A12 Chelmsford to A120 widening scheme

8.16 Statement of Common Ground with Witham Town Council

Statement of Common Ground with Witham Town Council

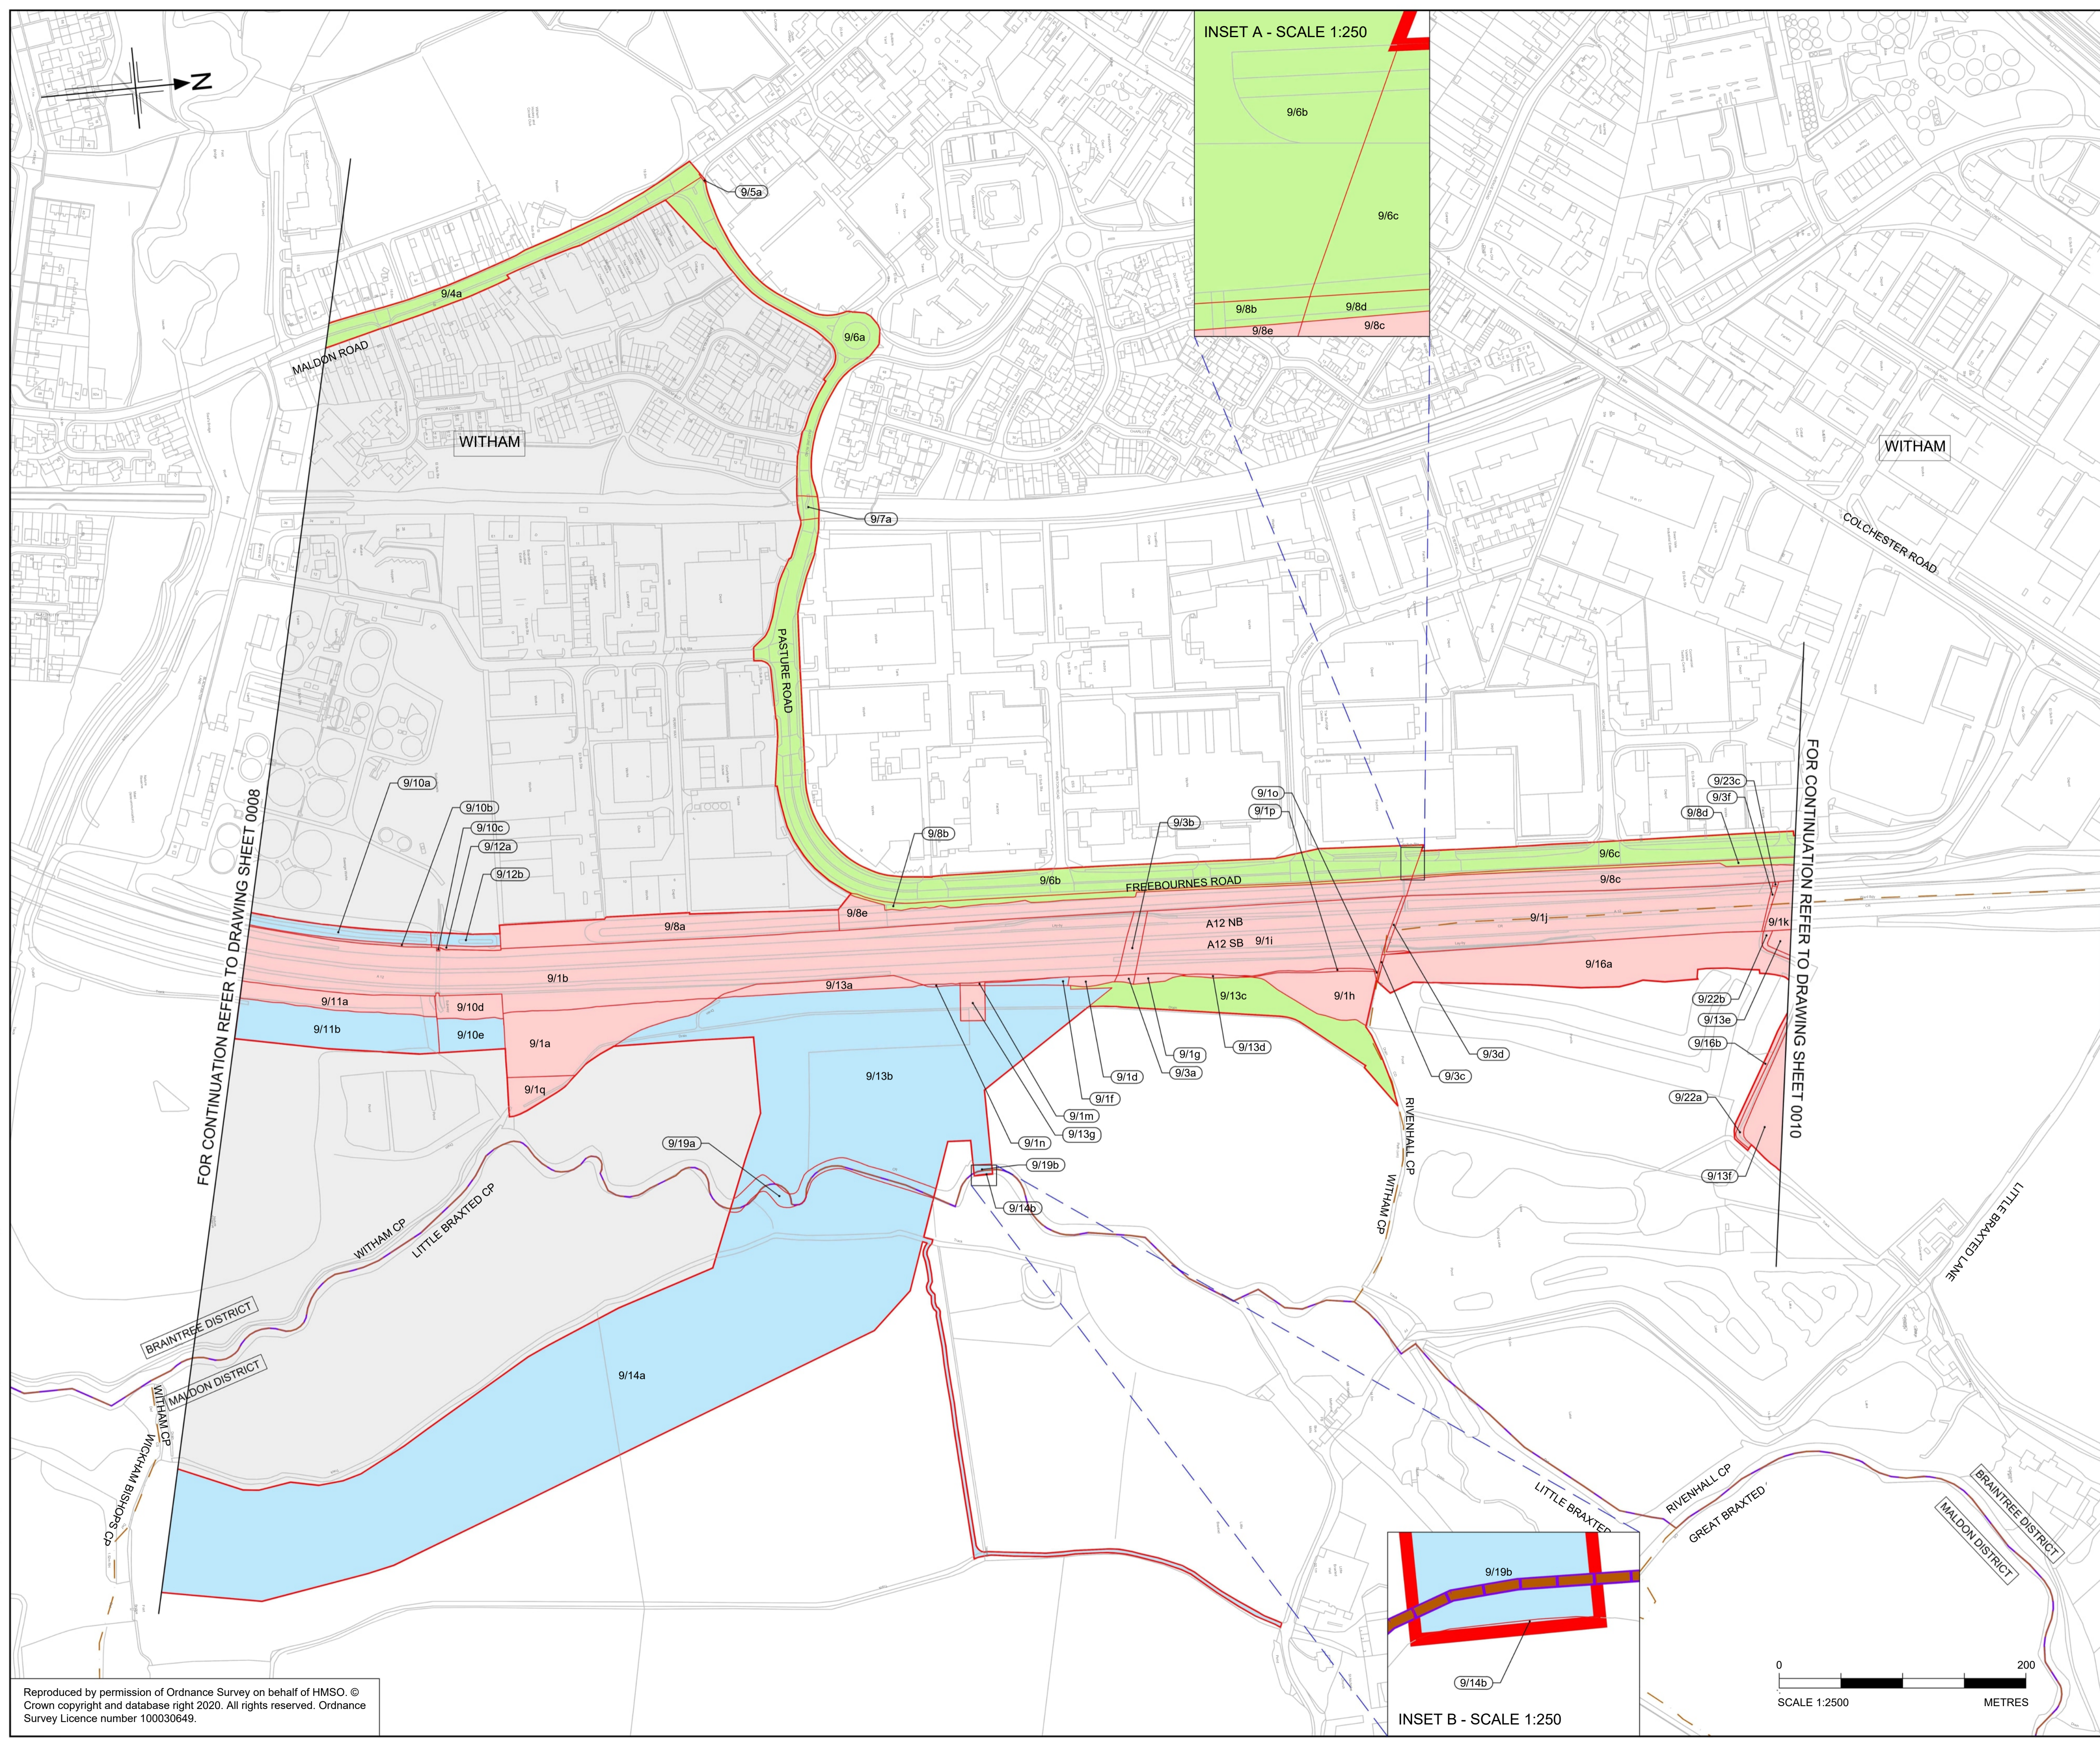
Ref	Issue	Doc Reference	Witham Town Council Position	National Highways Position	Status	Date
1	Loss of Land at Whetmead Nature Reserve		<i>Loss of land at Whetmead Nature Reserve.</i>	<p>A narrow strip of land (plots 8/47a and 9/11a shown on sheets 8 and 9 of the Land Plans [REP4-005]) from the Whetmead Local Nature Reserve, adjacent to the A12 needs to be acquired for the widening of the A12.</p> <p>Adjacent to plots 8/47a and 9/11a, land is required temporarily for modifications to utilities, crossing or adjacent to the A12. Permanent rights need to be acquired over this land (plots 8/47b and 9/11b shown on sheets 8 and 9 of the Land Plans [REP4-005]) for the utility companies.</p> <p>Access to Whetmead Local Nature Reserve from Blackwater Lane is to be maintained where</p>	Agreed	31/05/2023

Drawing title: **ENVIRONMENTAL STATEMENT ENVIRONMENTAL MASTERPLAN CH. 19600/20000 TO 21400 SHEET 8 OF 21**

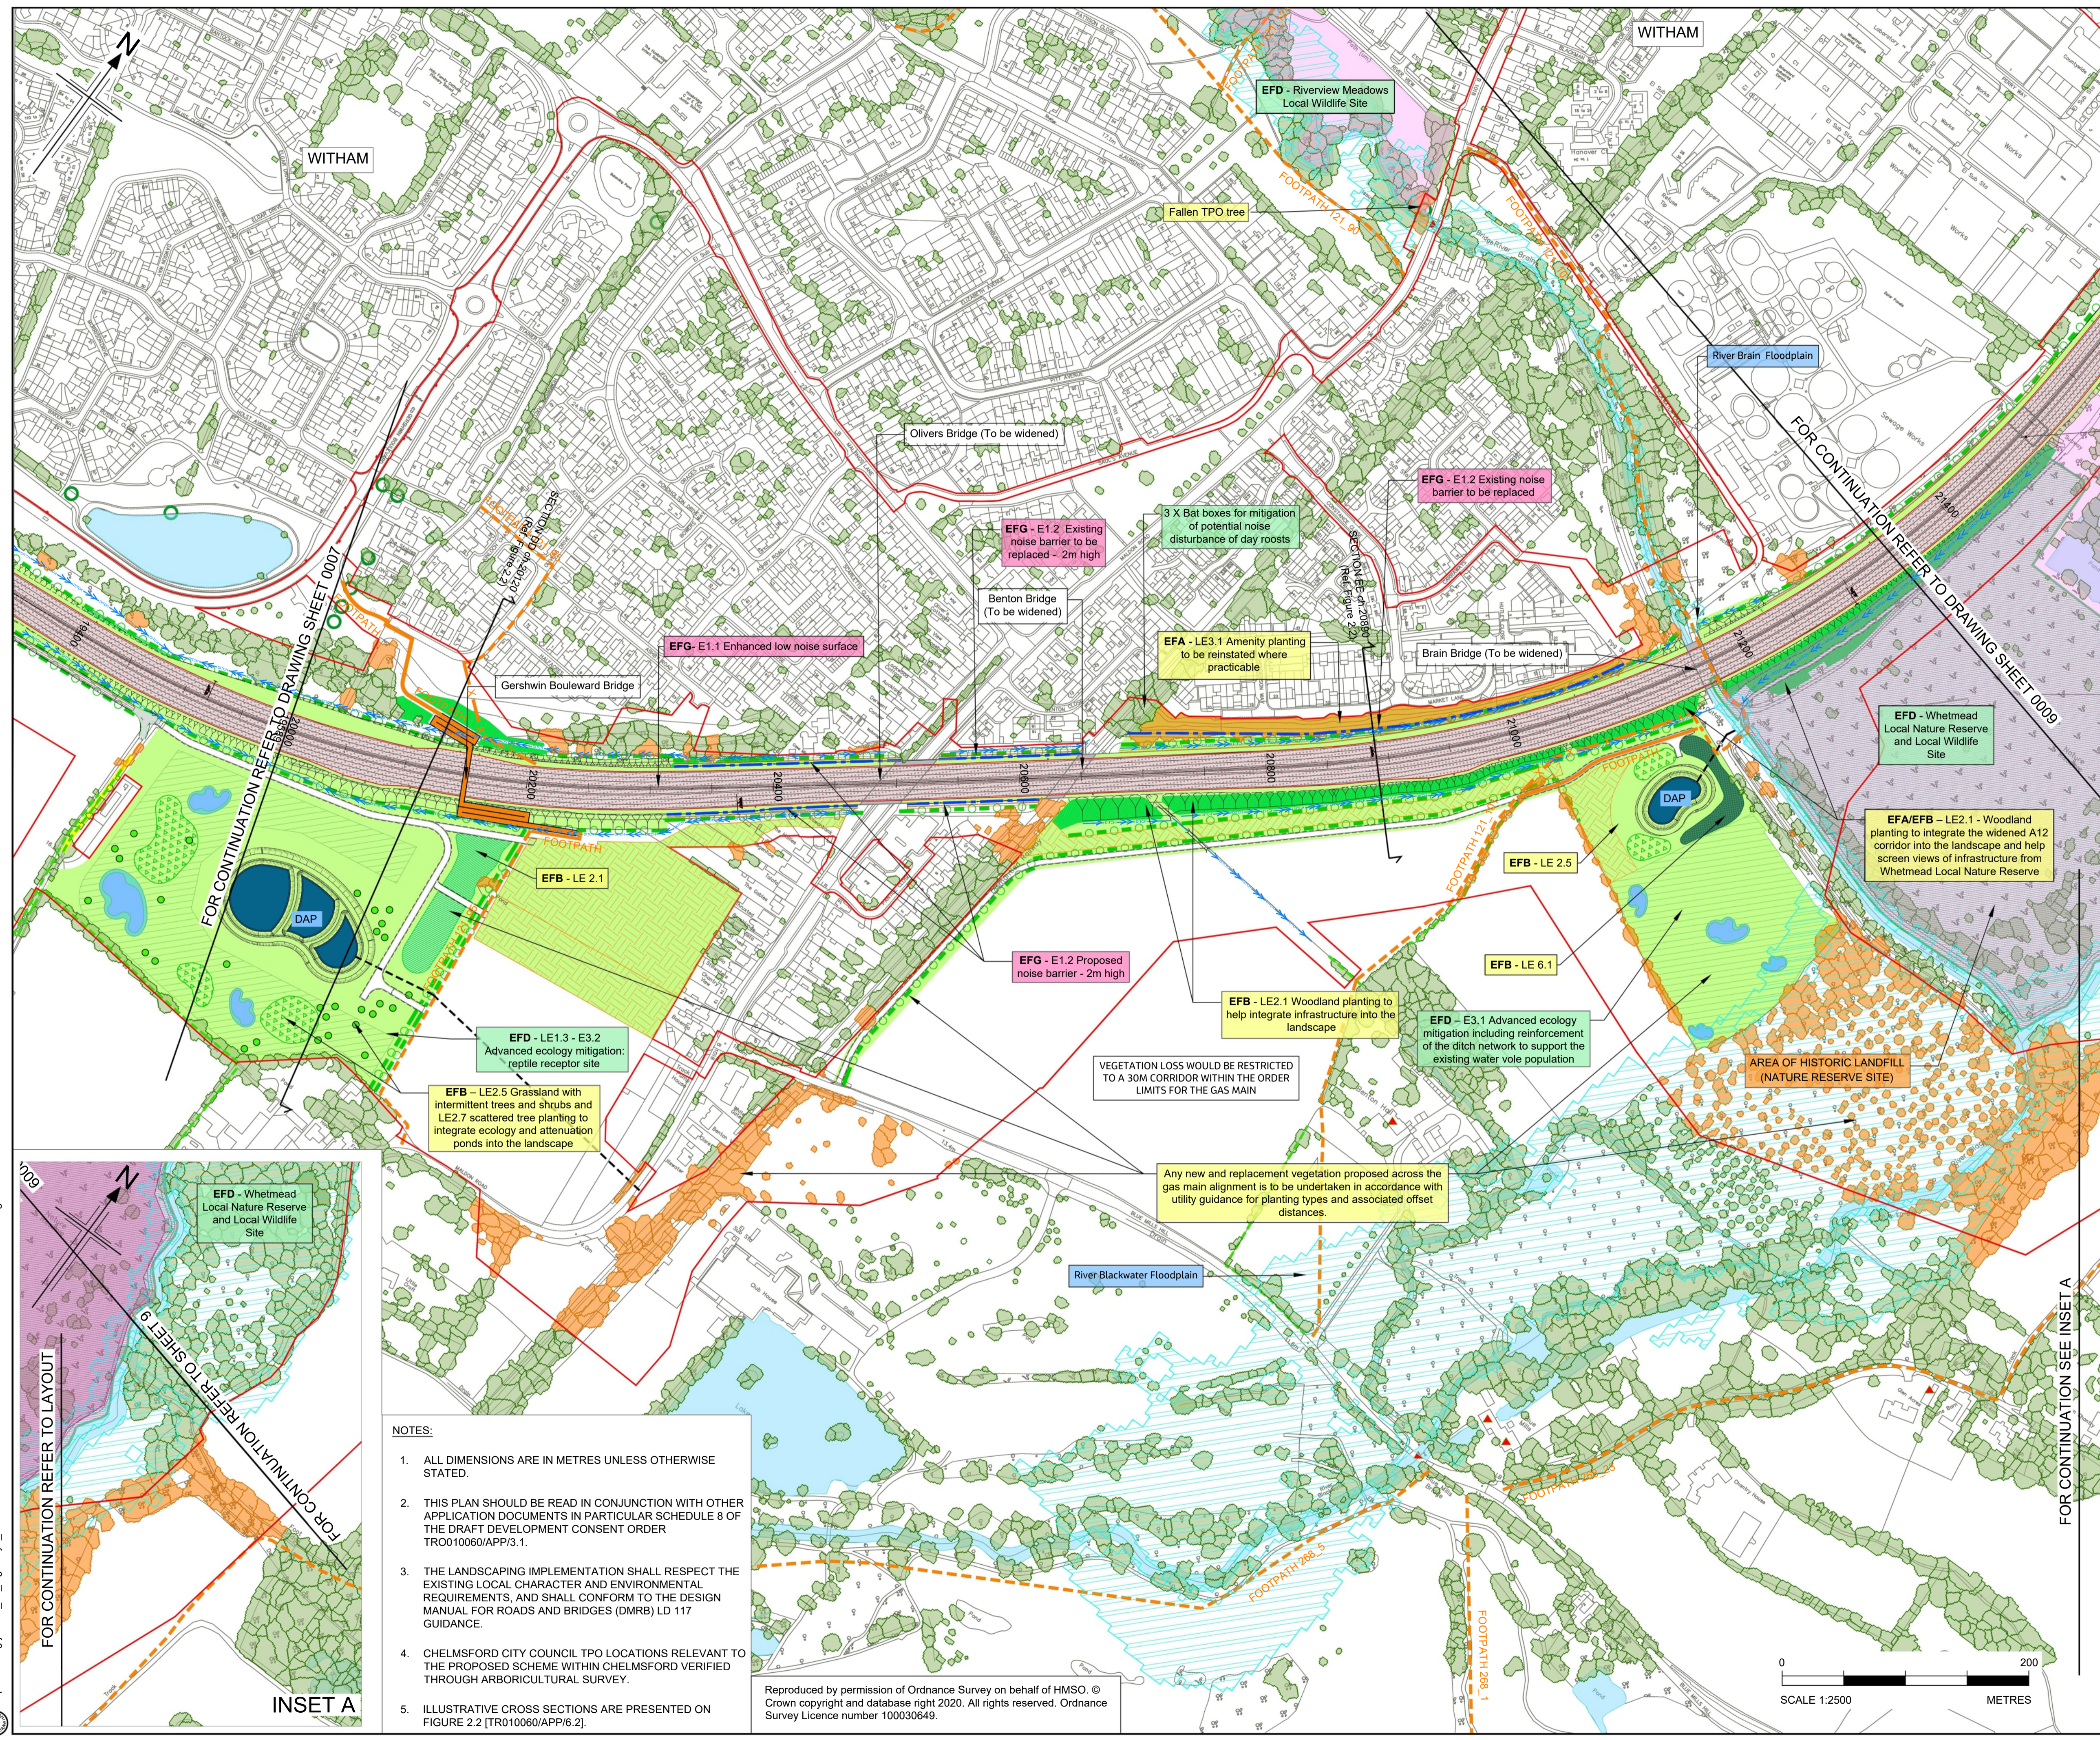
Ref	Issue	Doc Reference	Witham Town Council Position	National Highways Position	Status	Date
			<i>ay leads to the anticipation of greater operational noise of the road upon the completion of the construction works.</i>	Refer to Environmental Masterplans Part 1 (sheets 6, 7 and 8) [APP-086] and Part 2 (sheets 9 and 10) [APP-087].		
6	Construction noise	<p>Environmental Statement, Chapter 12, Noise and vibration [APP-079]</p> <p>First iteration Environmental Management Plan (EMP) Appendix A: Register of Environmental Actions and Commitments (REAC) [TR010060/APP/6.5]</p>	<p><i>Noise during the construction period.</i></p> <p><i>WTC are happy subject to clarification that local residents will be made aware of potential high levels of noise, i.e., piling. An assurance has been given that the Community Liaison Team will provide information in advance of the works.</i></p>	<p>National Highways continues to investigate the construction methodology for the retaining walls on the north side of the A12 through Witham, in particular at Market Lane. The proposed retaining wall impacts upon the existing Market Lane retaining wall and would need to be removed to allow the construction of the proposed retaining wall, prior to being reinstated.</p> <p>National Highways will, if practicable, aim to maintain the existing noise barrier in Market Lane during the construction works.</p> <p>Piling works would predominately be undertaken during daytime working hours, however there is likely to be a requirement to undertake a small percentage of piling works during the night, where dictated by project</p>	Agreed	31/05/2023
